Address: 256 Oxford Road Cleckheaton BD19 4PY

Application number: 2025/91472	
What is the application for?:	Change of use and alterations to first floor office to form one apartment
Address of the site or building:	workshop/office rear of, 258a, Oxford Road, Gomersal, Cleckheaton, BD19 4RE
Postcode:	BD19 4BZ

REV	DATE	AMENDMENT
CLIENT :		
Mr C Bould		
PROJECT :		
Proposed Office Conversion Rear of 258a Oxford Road Gomersal		
DRAWING TITLE :		
Proposed Elevations		
SCALE:		DATE:
1-100@A3		May 2025
DRAWN:	CHECKED:	DWG NO. REVISION:
NC	CB	BB/08

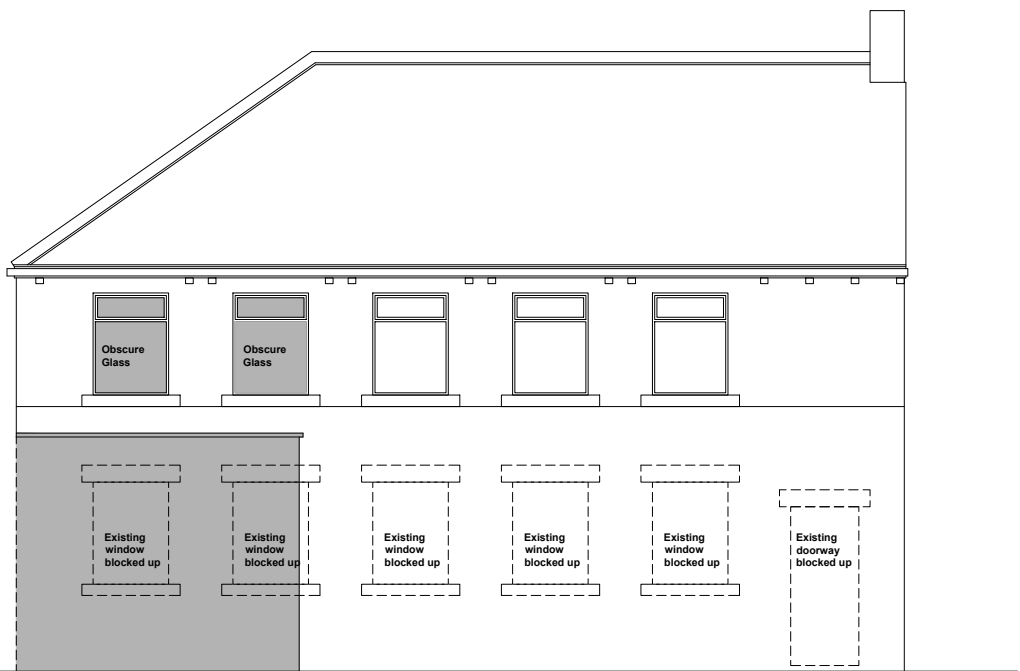
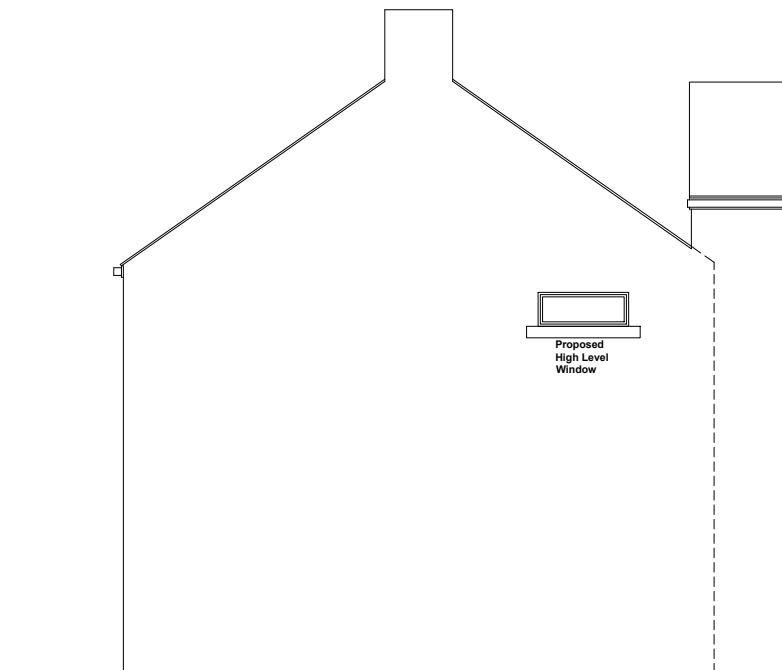
Type of comment: A general comment	
Do you wish your comments to be published on the website anonymously?	No
<p>The building is late 1800s, pebbled dashed and with frosted windows on the property preventing direct sight into the garden of 256 Oxford Road. I am concerned that the application includes clear windows which would cause a loss of privacy to the garden of the immediately neighbouring 256, Oxford Road, though not into the house itself.</p> <p>I note that in 2006 planning application number 06/62/90956/E1 was submitted for the current building to be demolished and a house erected in its footprint. This planning statement described the building as 'generally in poor structural condition with defects particularly to the North East Elevation'. Now twenty years older, is the building suitable for conversion while retaining the plasterer's workshop? The original idea of demolition and rebuild on the footprint seems to make more sense.</p> <p>It is my opinion that the enhancement to the residential nature of the yard is to be welcomed, once the structural integrity and windows overlooking neighbouring properties have been considered and mitigated.</p>
